RE: LU/297/19/PL - Land to rear of 141 Wick Street, Littlehampton, BN17 7JY

Thank you for your email, dated 13th January 2020.

458 - DPA 04

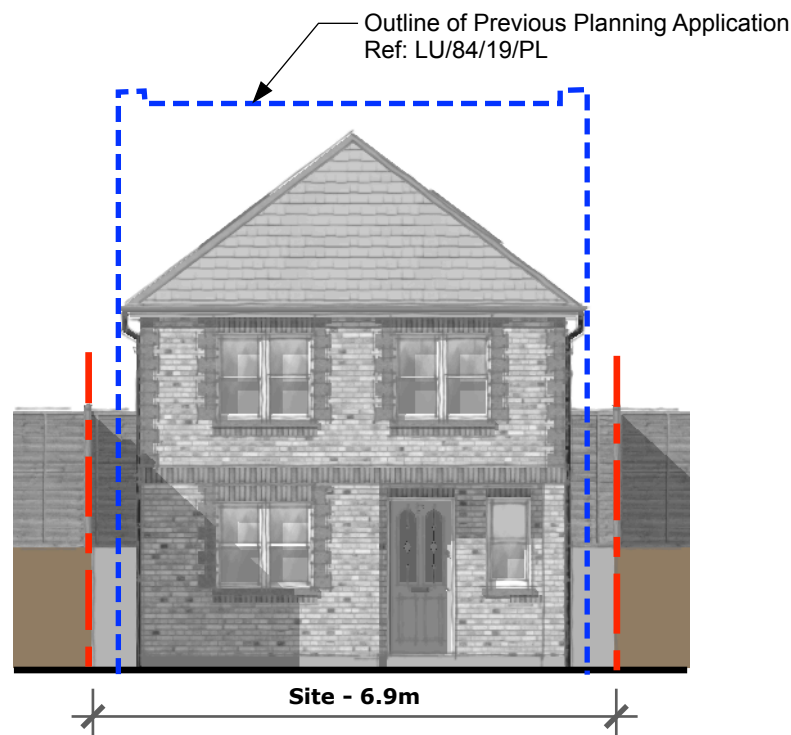
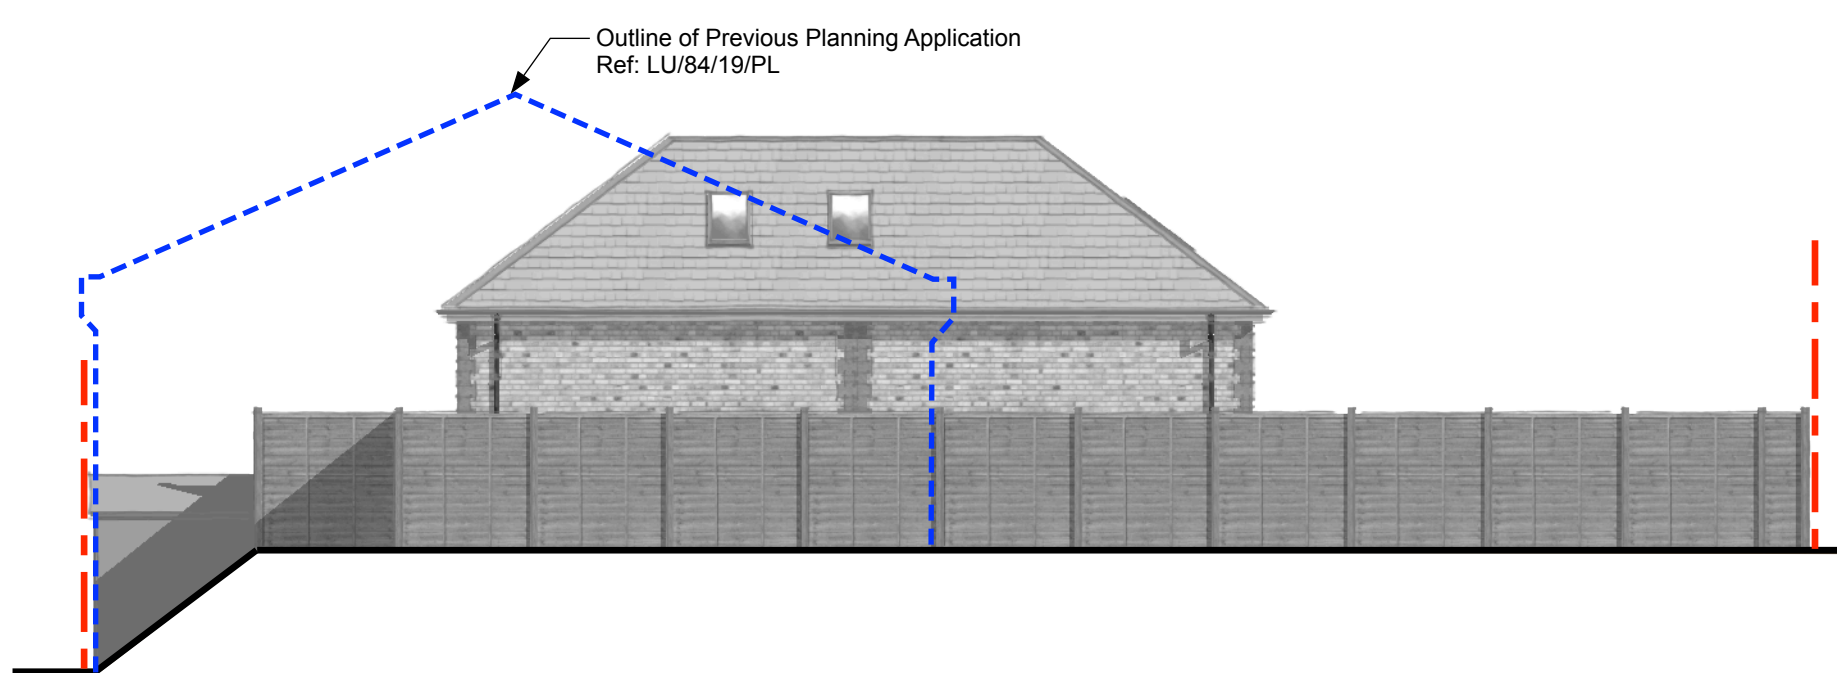
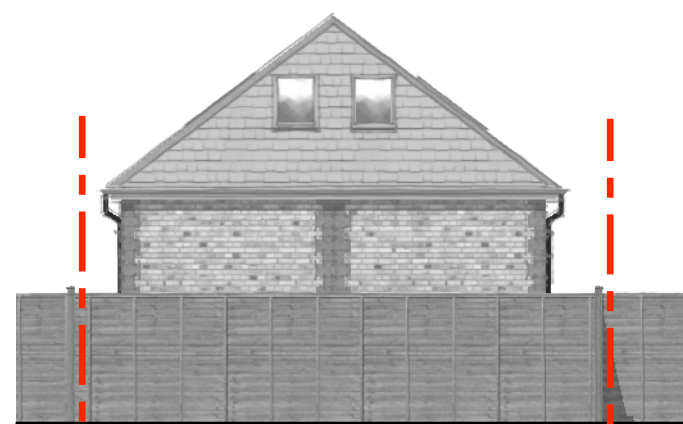
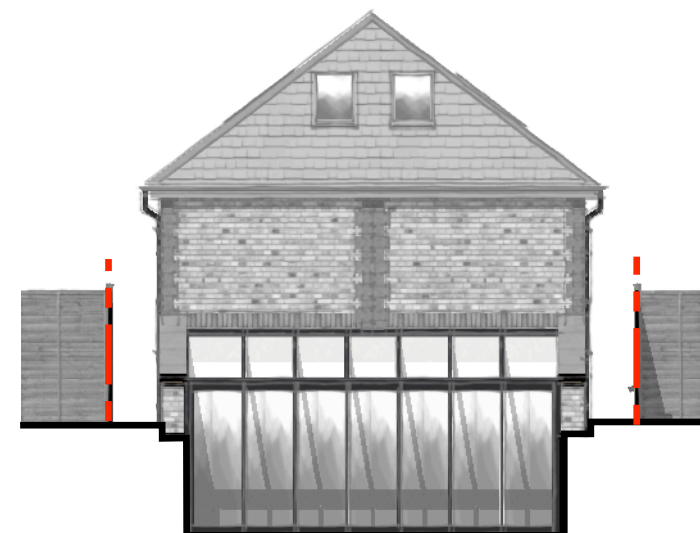
Overlooking north/south – what are the levels to plots to the north/south?

With the latest revised drawings we have addressed the matter of overlooking to the North and South and there are no windows that over look in these directions, so we feel the proposed design does not present any overlooking issues, in the revised design we have also reduced the size and mass and height of the building so it is smaller than before, there is also now a 700mm gap each side of the North and South boundaries.
